Application number: 2026/90702	
What is the application for?:	Demolition of existing outbuildings and erection of detached leisure building, c
Address of the site or building:	Fieldhead, Snelsins Road, Cleckheaton, BD19 3UE
Postcode:	HD1 3RE

Type of comment: An objection	
Do you wish your comments to be published on the website anonymously?	Yes

1 PROPOSED SITE PLAN

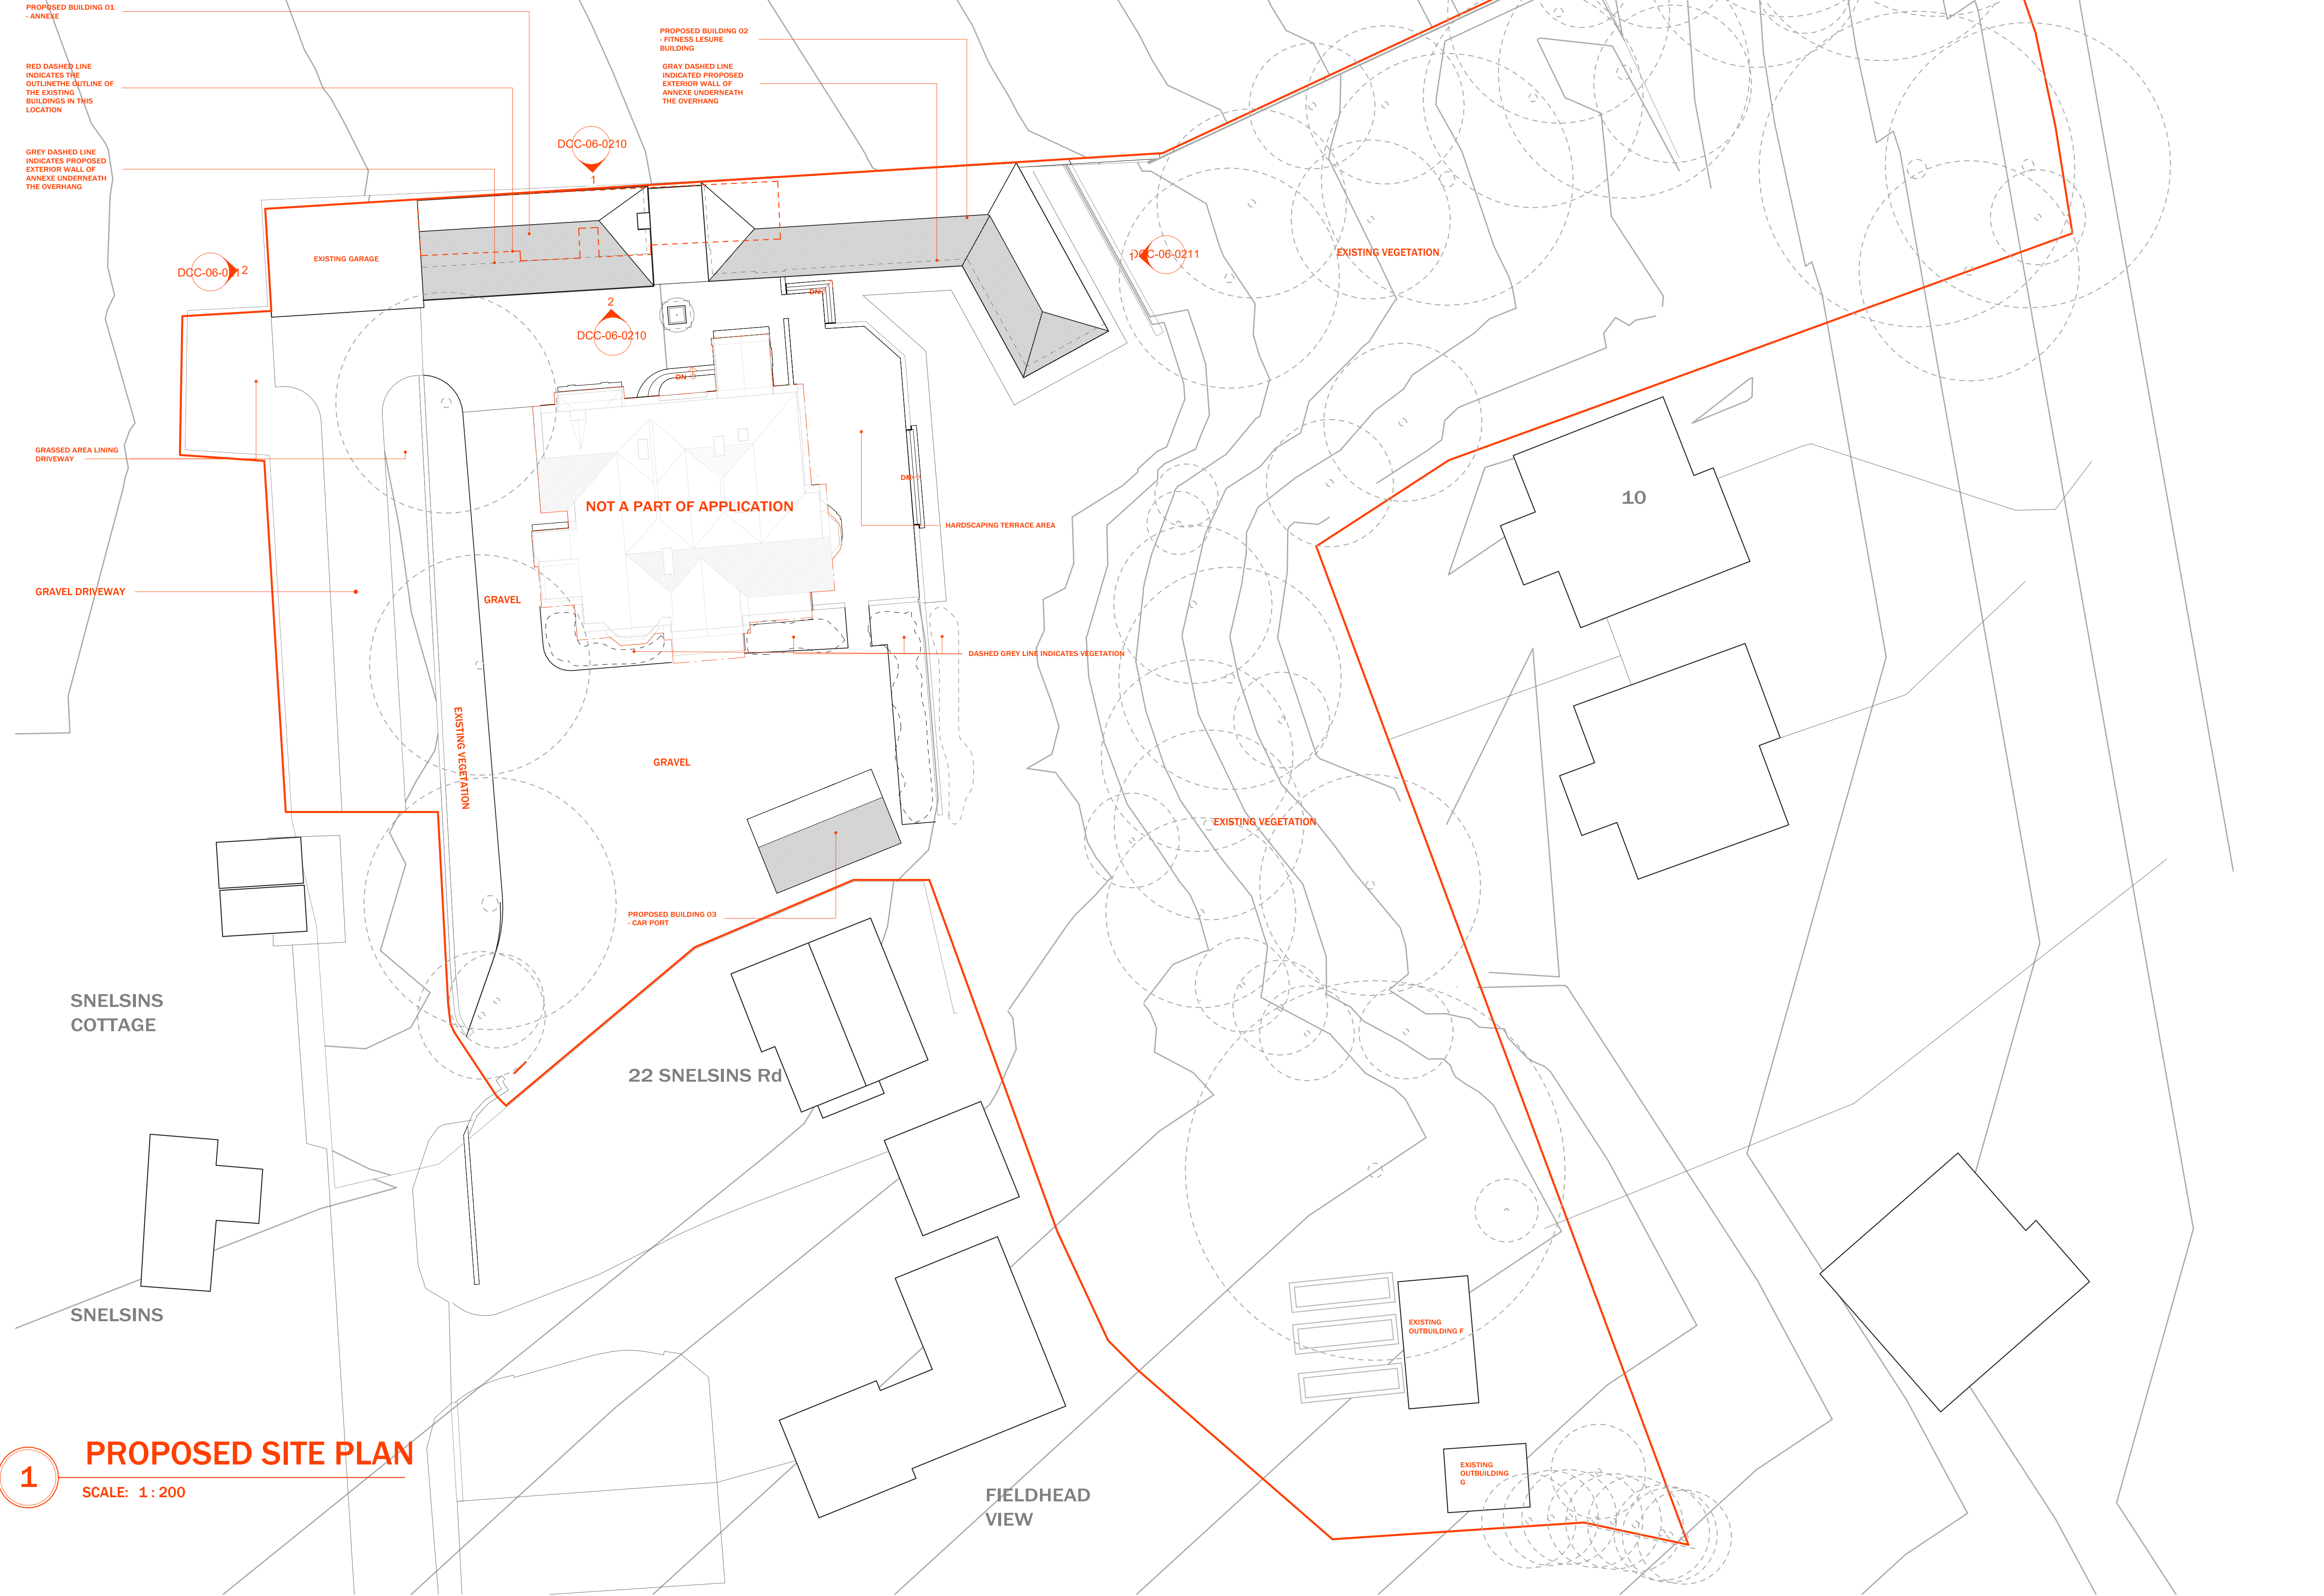
2. As the proposal stands we're very concerned about any further effect on trees and the landscape design, which impacts the local amenity. Further changes will harm the outlook from my home and garden.

5. The scale, height, and proximity of the extension will have a detrimental effect on sunlight and daylight to the back of our house. The extension means the footprint of the property creeps ever closer to our boundary with further light pollution.

PROPOSED
ELEVATIONS sht 01 OF
02
DCC-06-0210

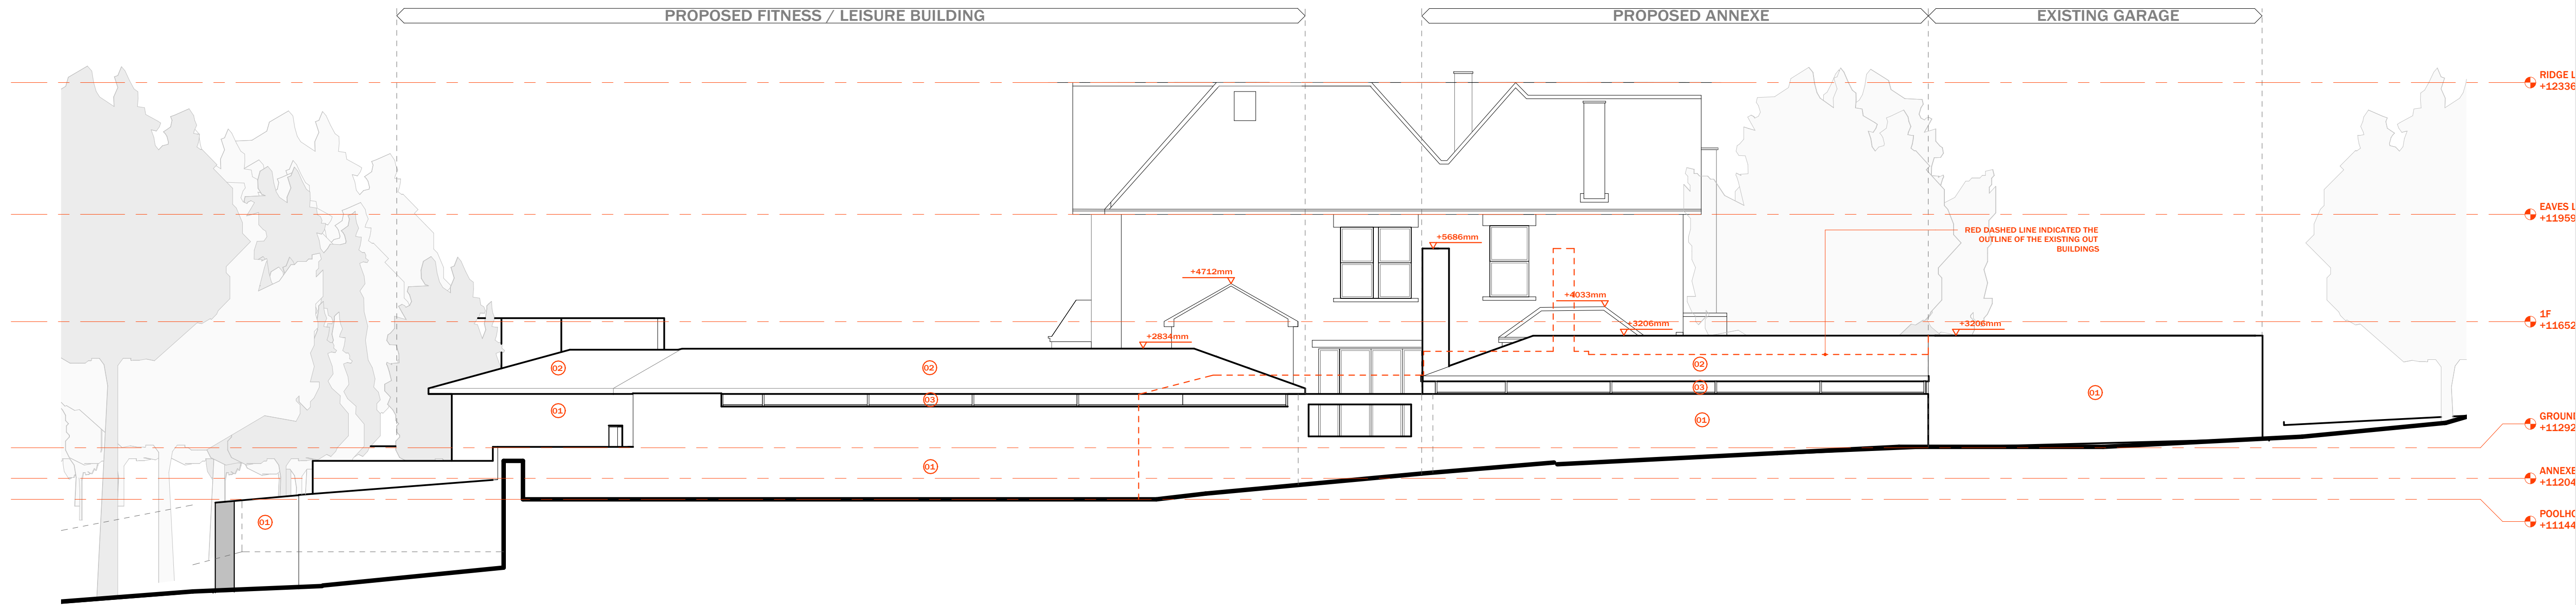
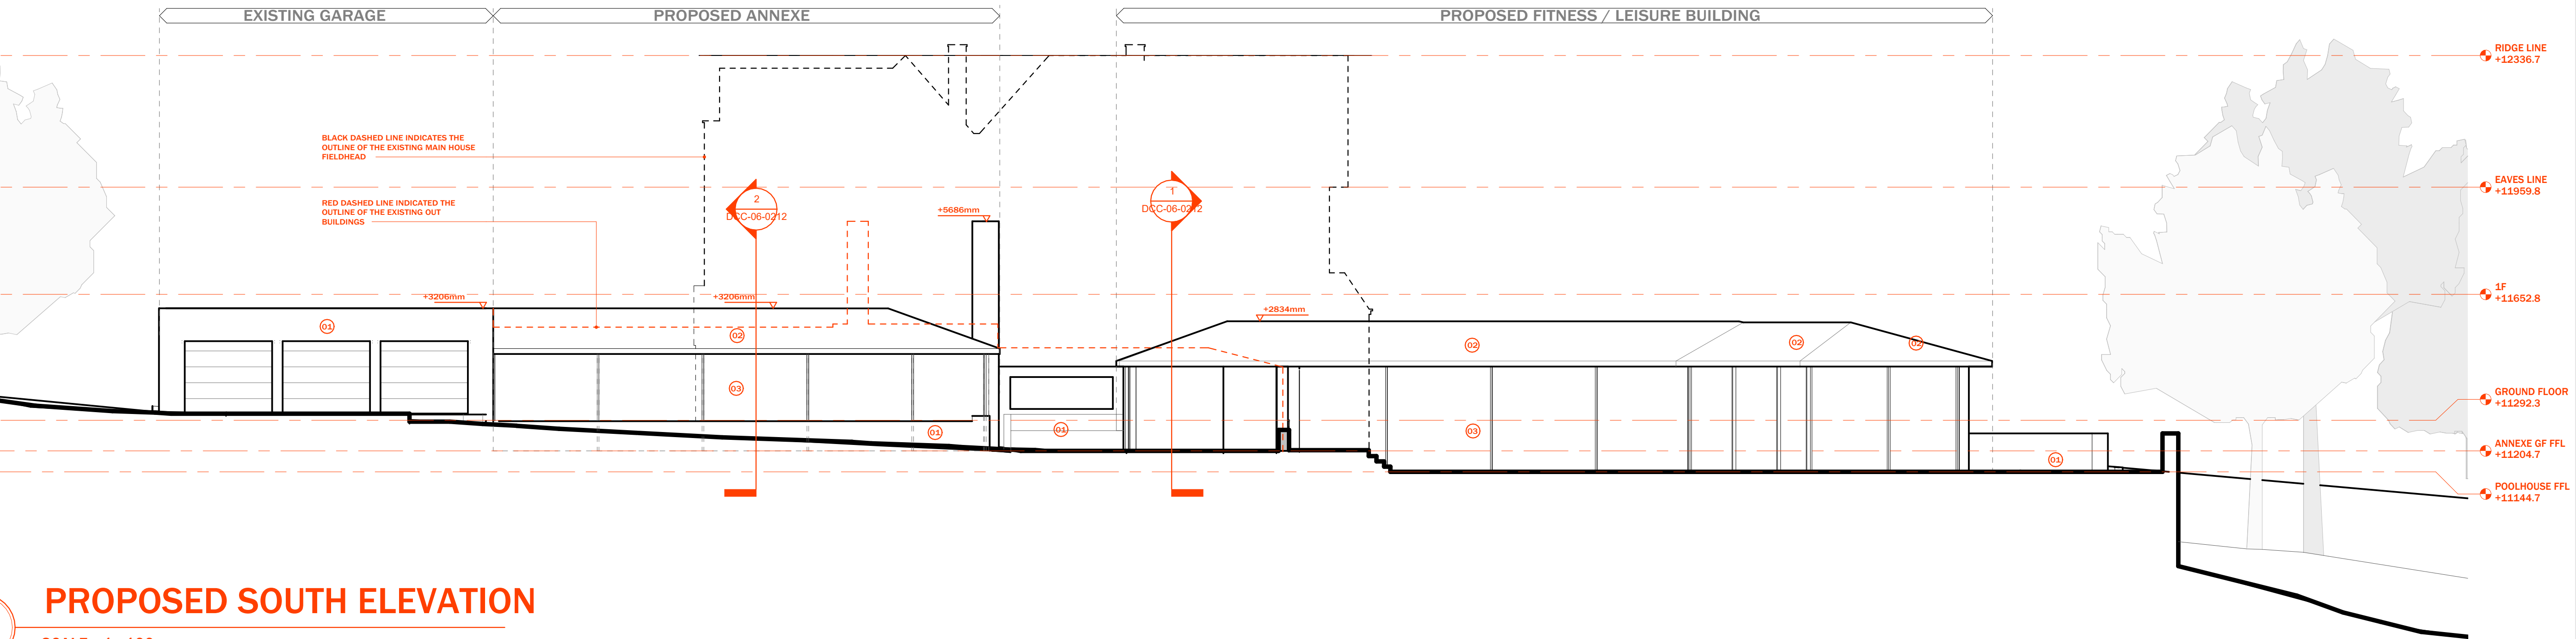
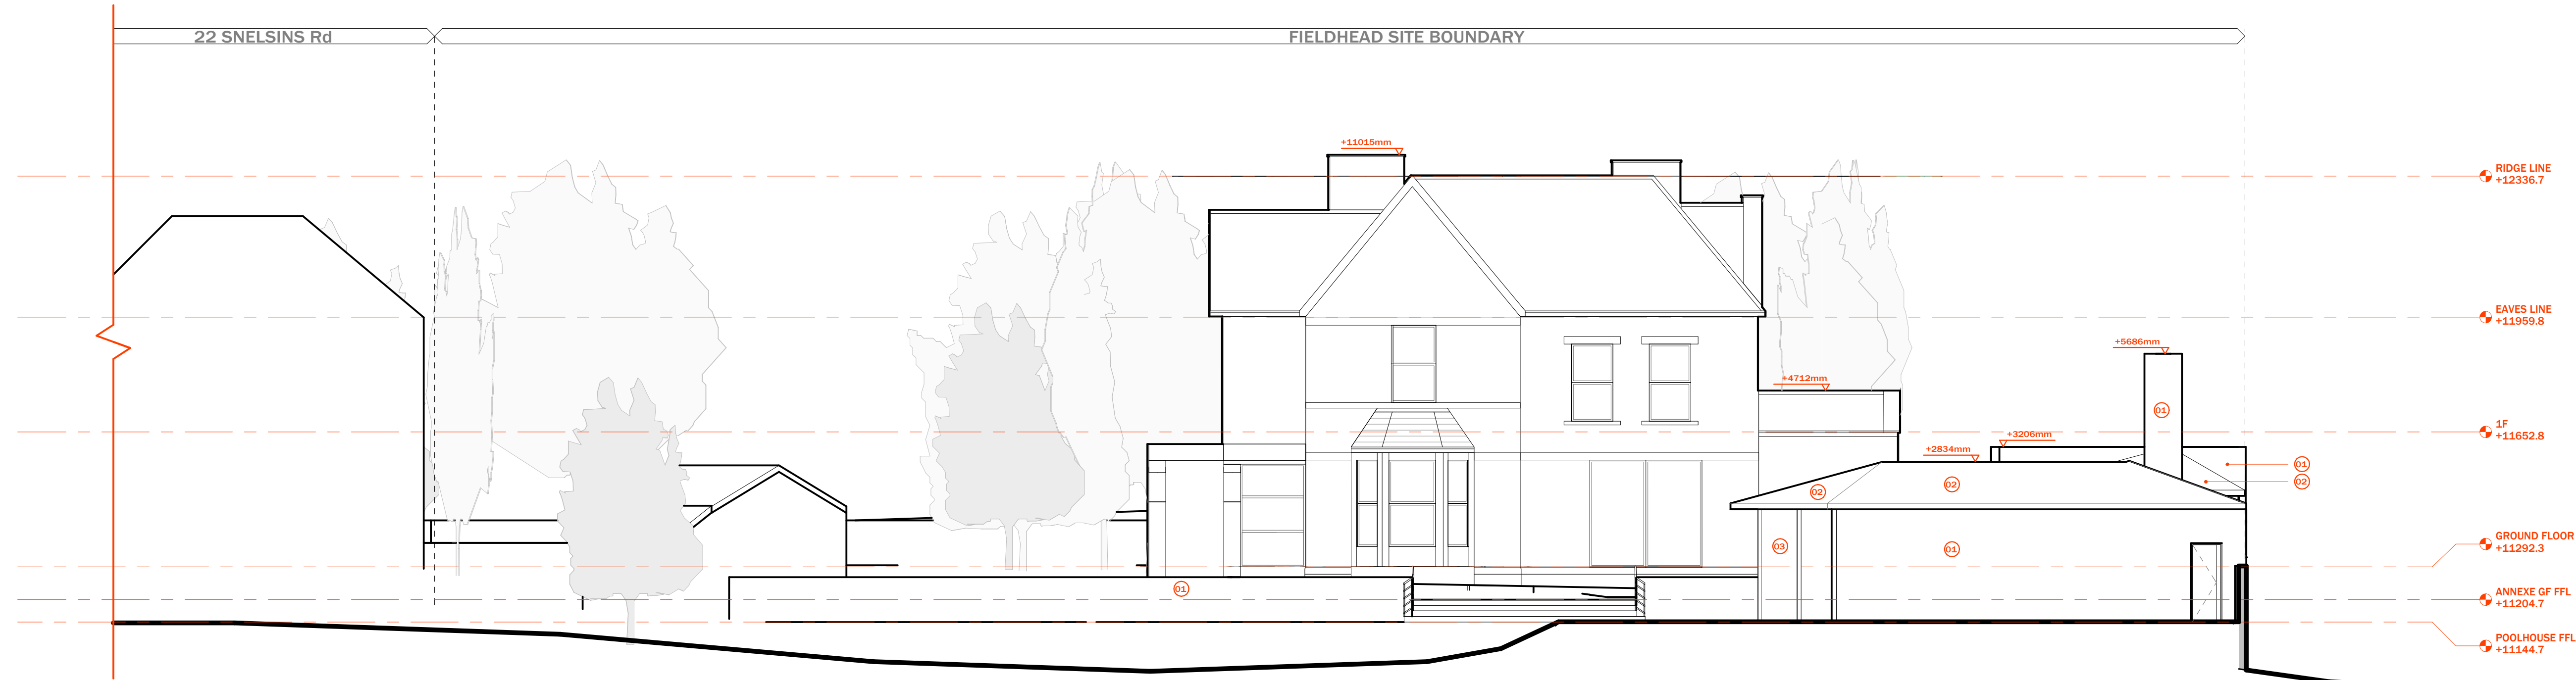
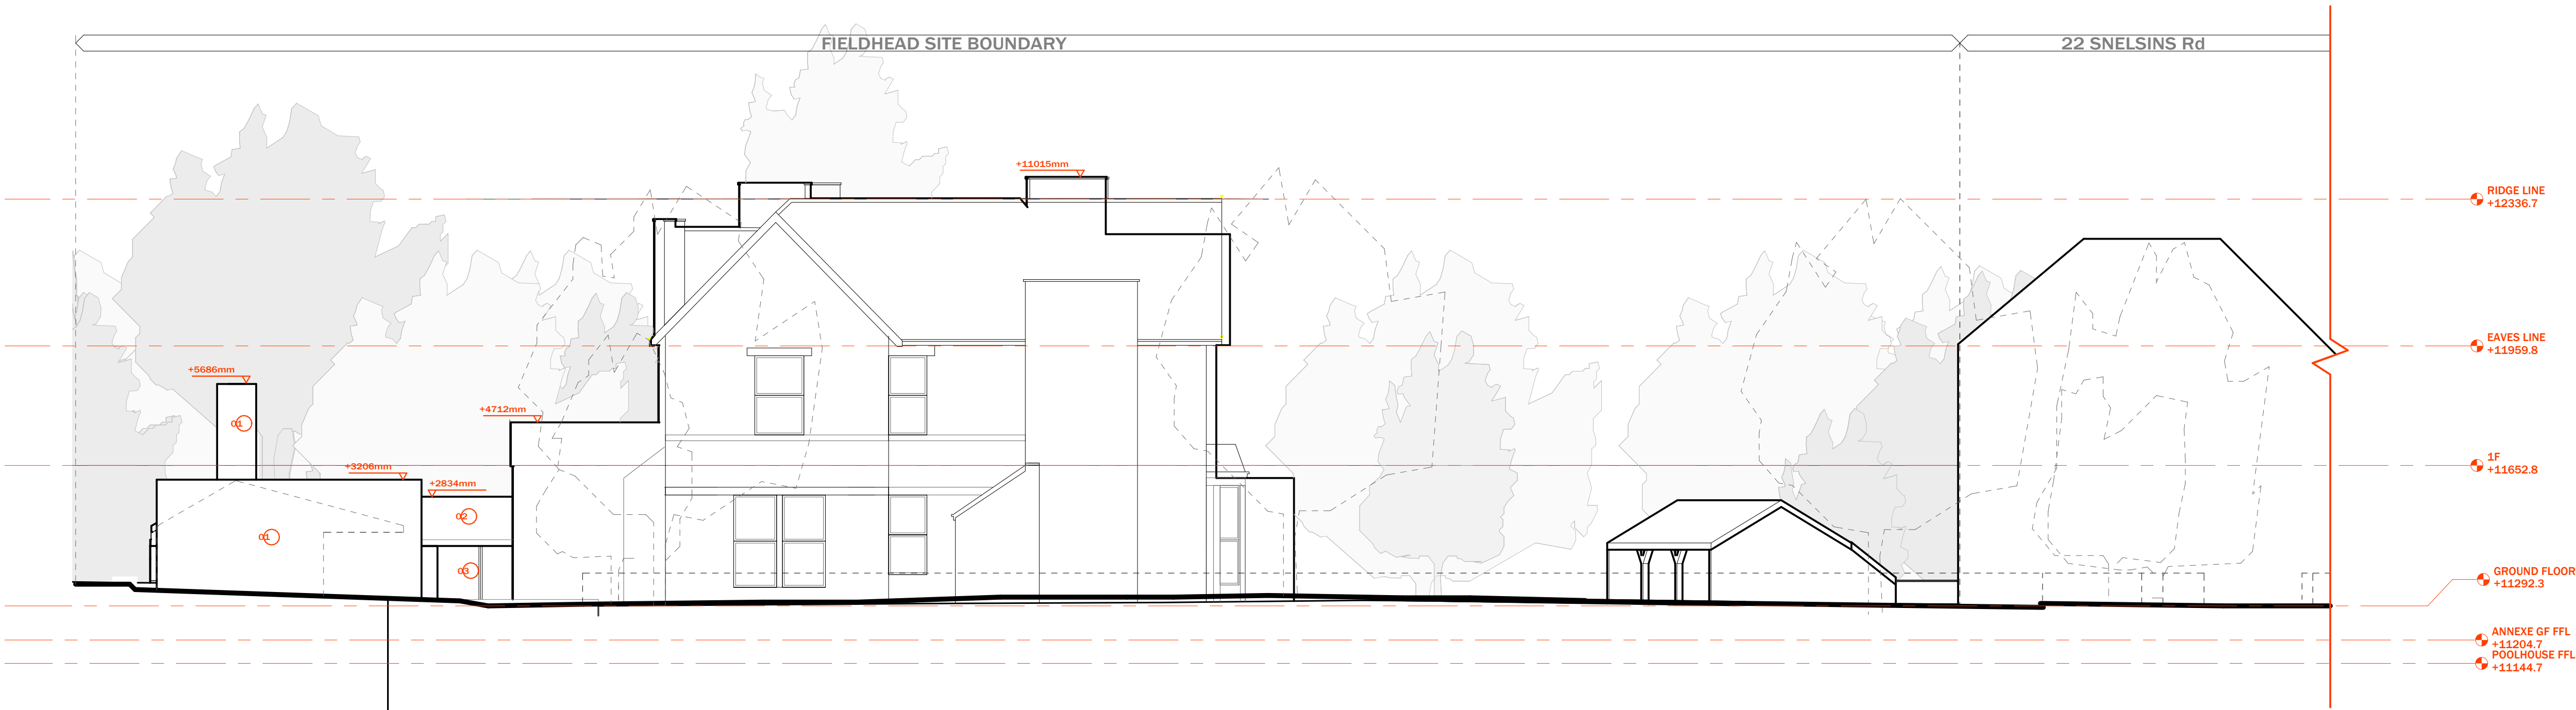
1. The very open nature, in particular the floor to ceiling windows, of the gym building and the pool complex is of significant concern. This seeming overbearing extension will be directly visible from every room at the back of our house including our kitchen, family room, 2 bedrooms and our garden, which creates a privacy issue for both properties. At the moment we have a high degree of privacy and the protruding nature of the leisure complex means that we will be directly overlooked and it creates an unacceptable loss of privacy.
